UPDATE TO OXFORDSHIRE COUNTY COUNCIL'S RESPONSE TO CONSULTATION ON THE FOLLOWING DEVELOPMENT PROPOSAL

Application No: 17/02534/OUT-3

Proposal: OUTLINE - The construction of a business park of up to 60,000 sq.m (GEA) of flexible Class B1(a) office / Class B1(b) research & development floorspace; parking for up to 2,000 cars; and associated highways, infrastructure and earthworks

Location: Land North Of Bicester Avenue, Garden Centre, Oxford Road, Bicester.

Title:  
Island Dimensions

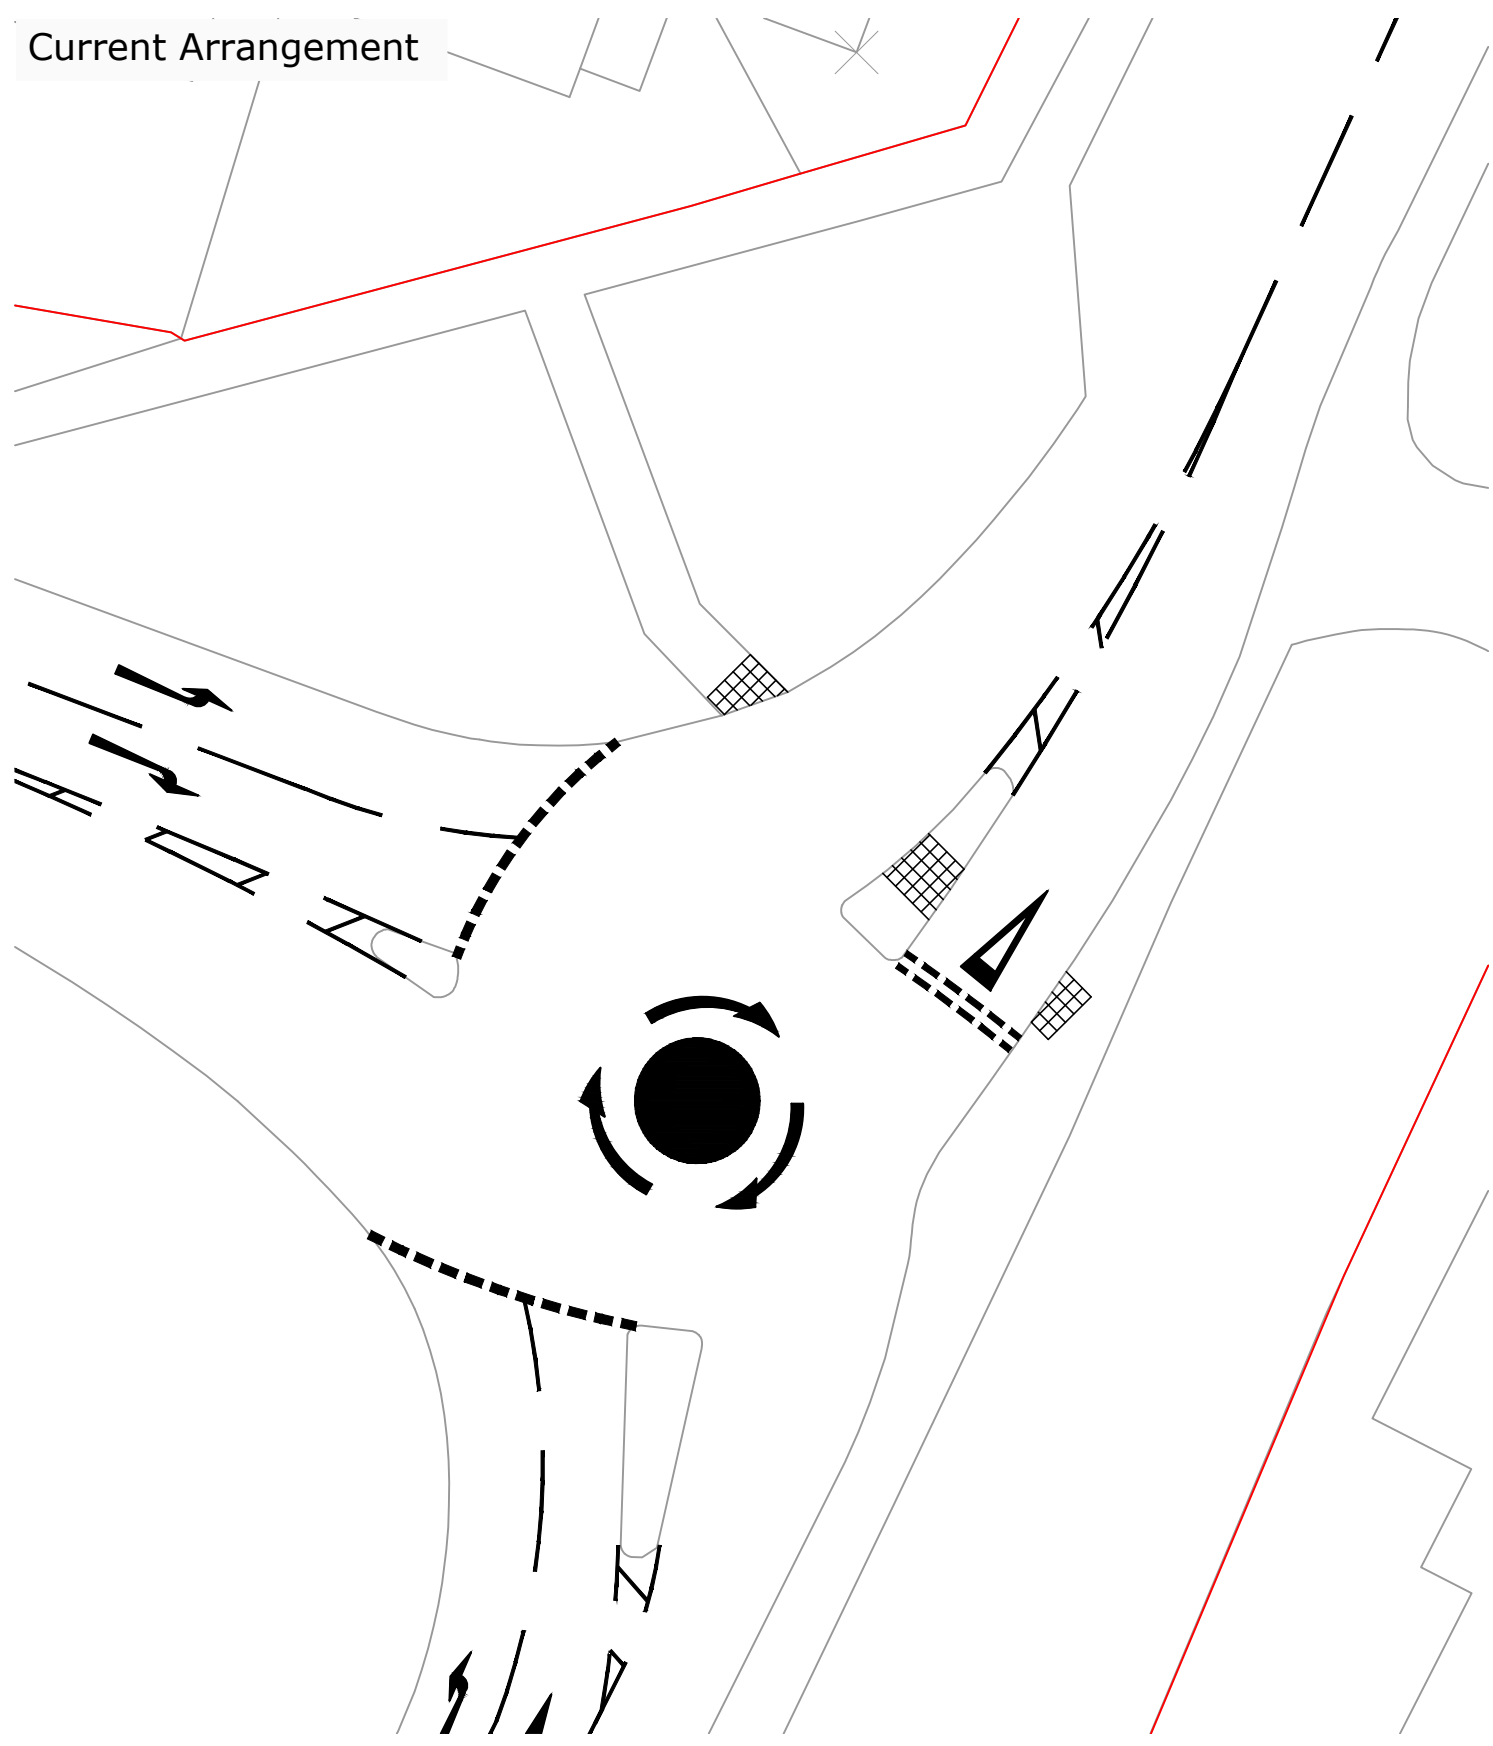
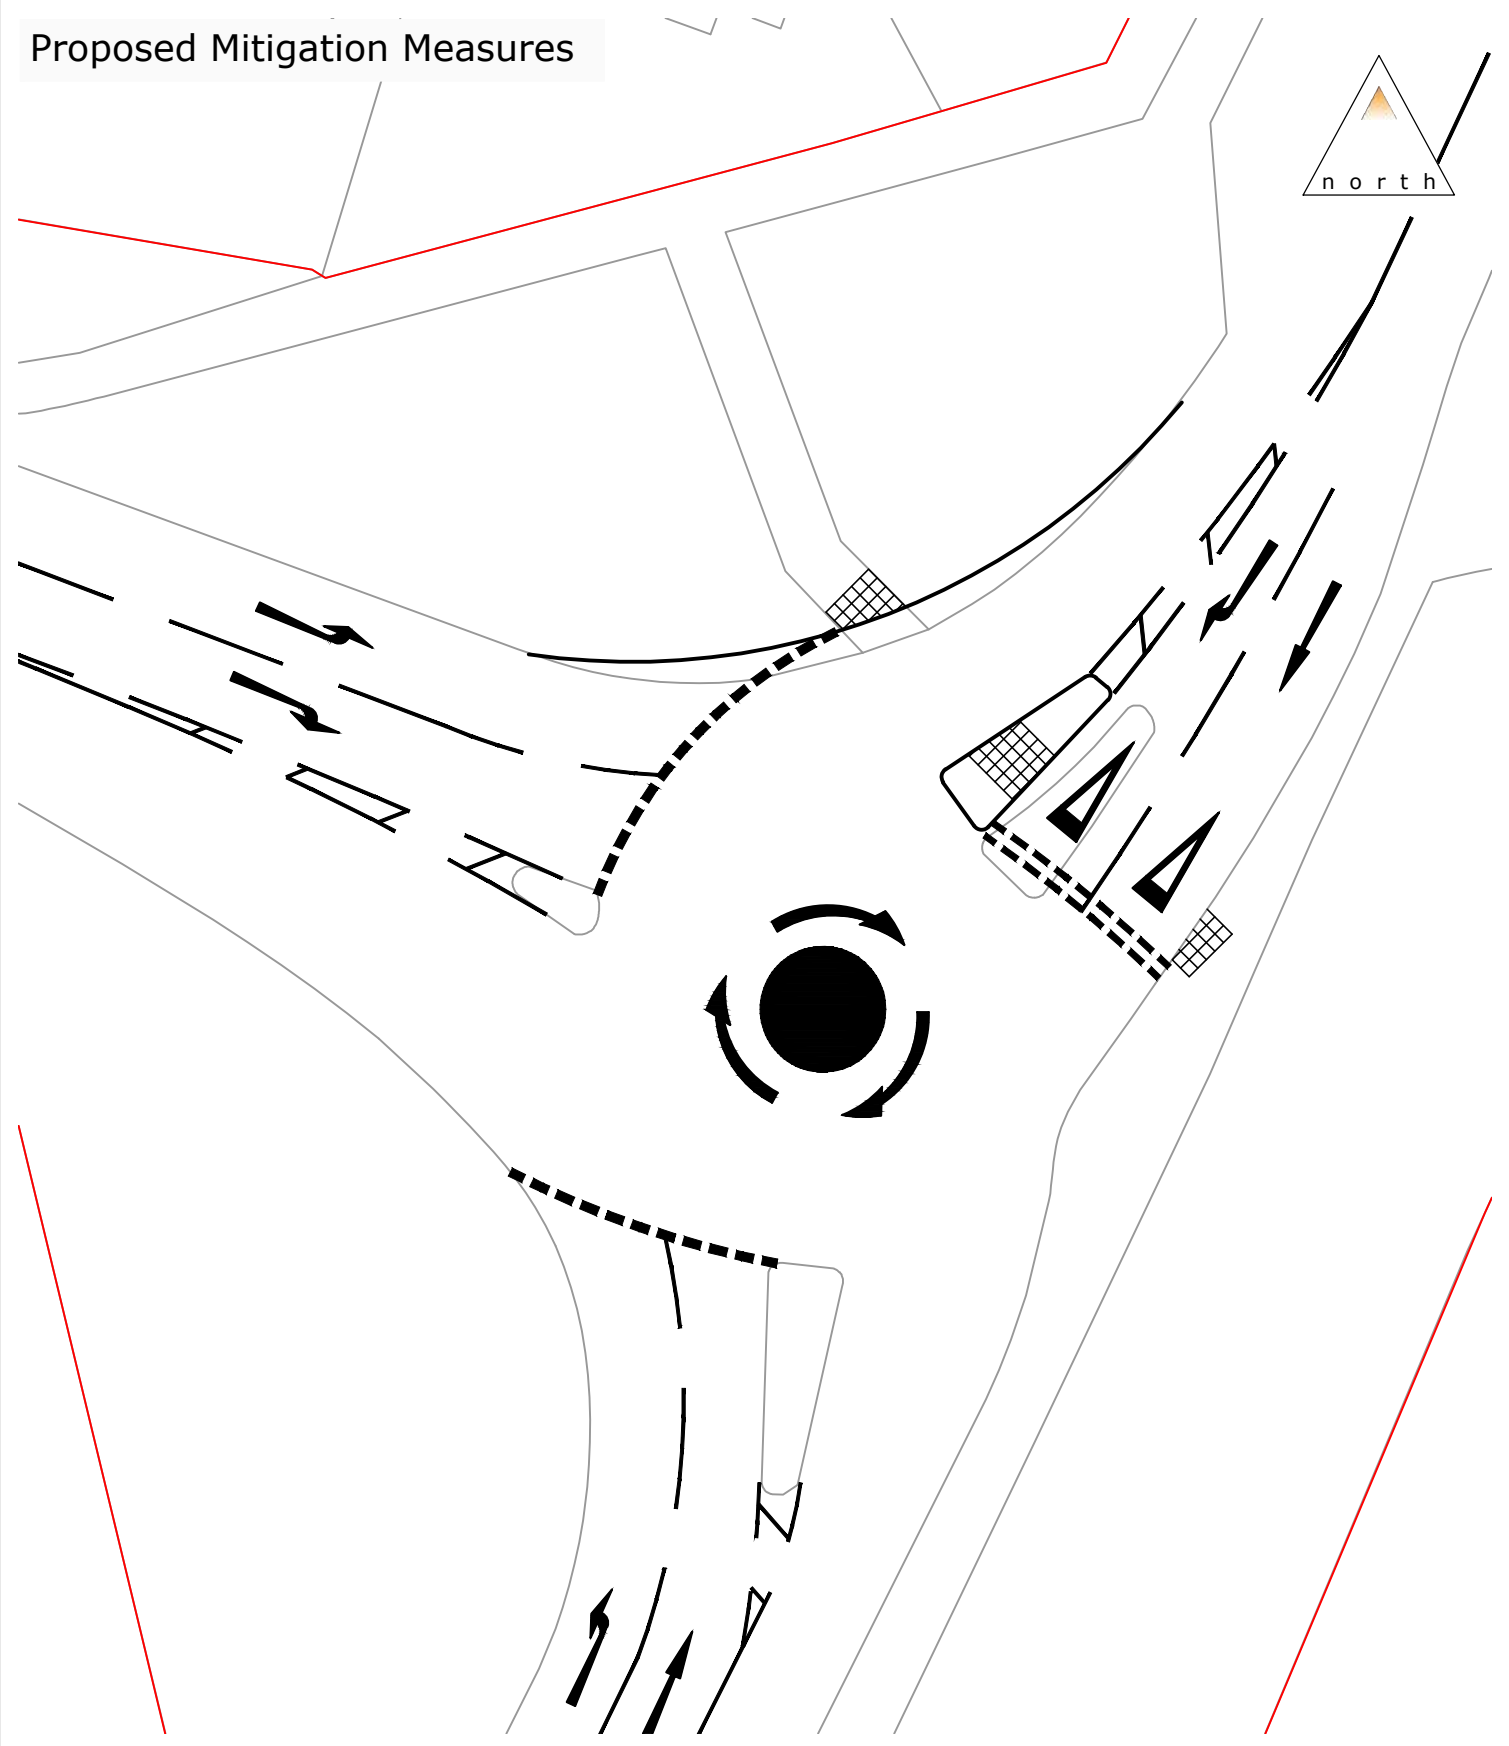
- With the highway mitigation proposed, the Lakeview Drive junction provides insufficient capacity for the whole development. It does not appear possible to increase the capacity of this junction within the highway boundary any further than already proposed. Given that access is not a reserved matter this needs to be resolved before a decision can be made by CDC's planning committee.

Notwithstanding the above points, it is clear that with the highway mitigation proposed, the Lakeview Drive junction provides insufficient capacity for the whole 60,000 m² development. Our response of 7th August 2018 highlighted the unacceptable queueing on Lakeview Drive. Further, it does not appear possible to increase the capacity of this junction within the highway boundary any further than already proposed. Whilst this has not been put directly to the applicant, understanding that the mitigation is not sufficient to meet the Highway Authority's concerns, one would have expected the applicant to come up with an amended or different scheme to provide additional capacity, if this were feasible. To provide sufficient capacity for the entire quantum of development proposed, it is likely that vehicles would need to be diverted away from the A41 by a scheme such as the South East Perimeter Road. To establish how much development could be carried out at the site without causing a severe impact on the highway network (prior to the SEPR or scheme of similar benefit being in place), errors with the modelling would need to be corrected and further tests carried out.

- Paragraph 8.6 discusses the access to the development, but only considers the off-highway roundabout junctions on Lakeview Drive from which the Office Park would take access. This interpretation of ‘access’ is also reflected in the conclusion at 8.16. Access onto the highway network is in fact at the junction of Lakeview Drive and the A41, and, as highlighted in our response, the Highway Authority considers the impact of the development on queueing at this junction to be severe, and that it is very uncertain as to whether there could be a suitable mitigation scheme that could be delivered within the highway boundary. As stated in paragraph 8.6, the means of access is to be considered as part of this application, and the principle of the development depends upon the access being acceptable. The following plan is copied below to give members an idea of the proximity of the proposed junction to the highway boundary:
